REQUEST

Current Zoning: RE-1 (research district)
Proposed Zoning: UR-2(CD) (urban residential, conditional)

Approximately 6.94 acres located at the northwest corner of William Ficklen Drive and Ben Craig Drive, west of Mallard Creek Road and east of WT Harris Blvd.

The petition proposes development of a vacant site in the University Research Park area for up to 82 single-family attached townhomes.

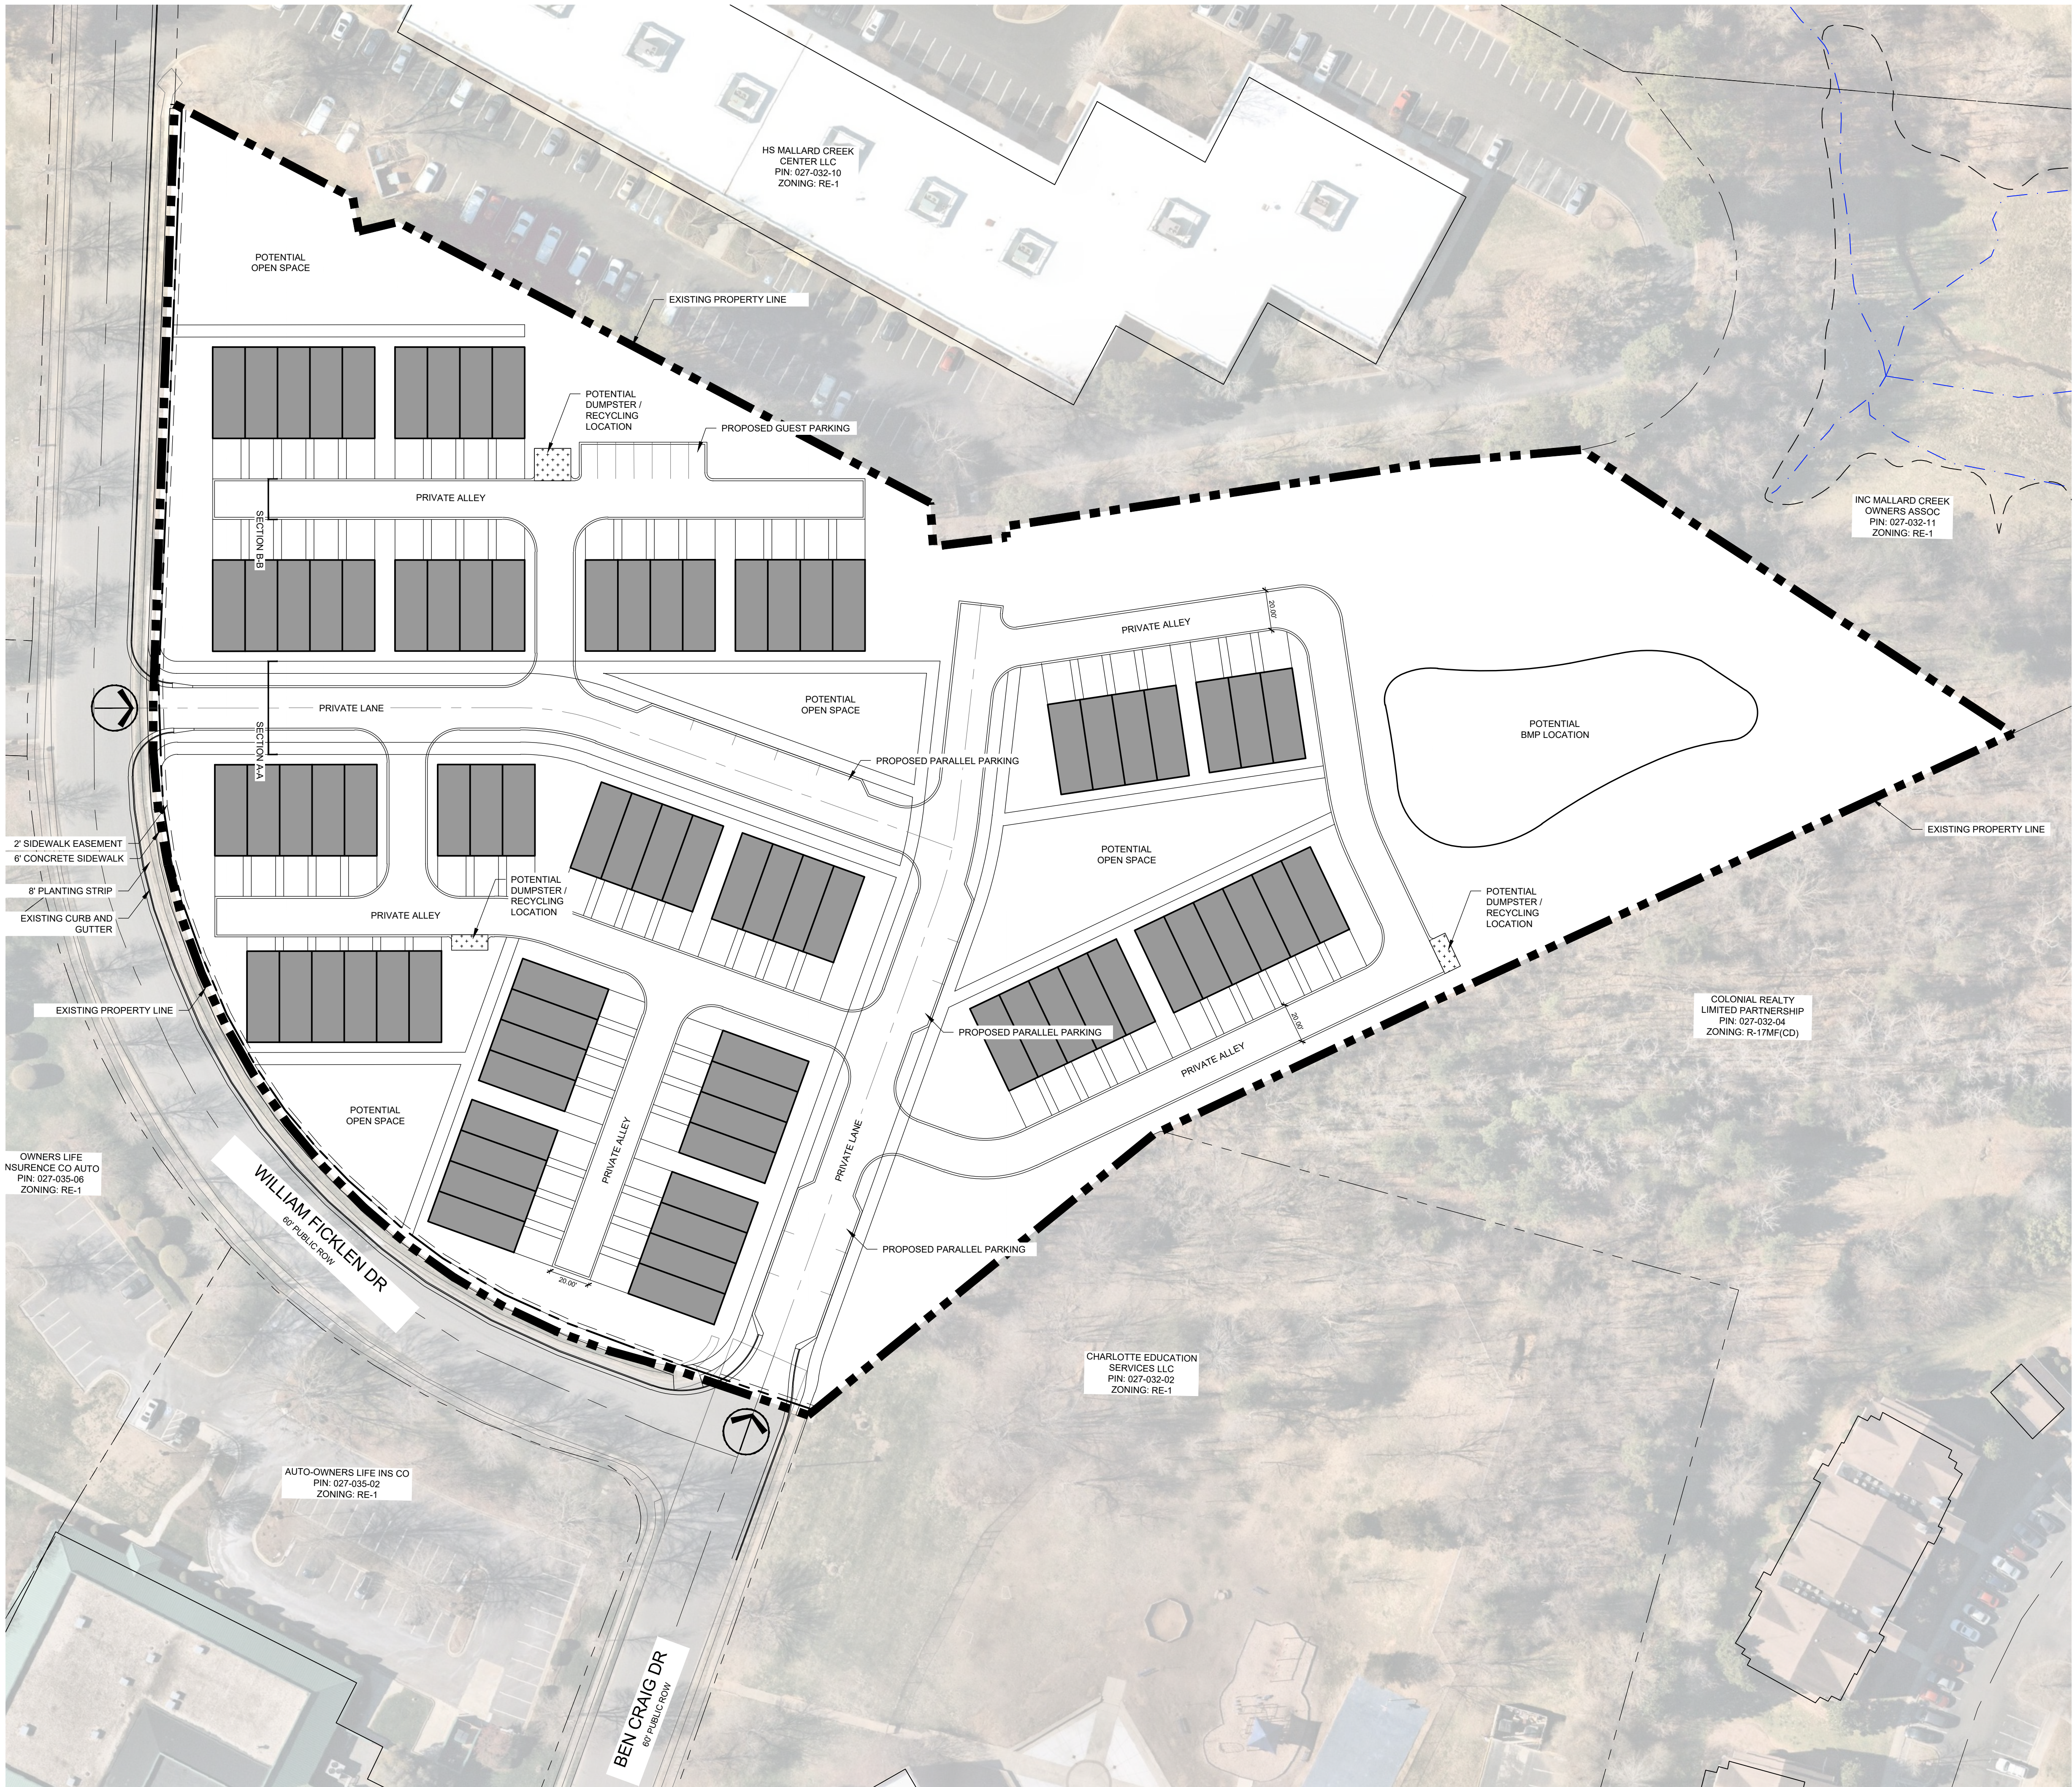
4. Revise site plan to show proper separation between the proposed on-street parking and the intersection. A minimum of 20-feet is required from the curb return to the parking stall.

6. Provide an 8 foot sidewalk and an 8 foot planting strip along frontage of William Ficklen Drive.
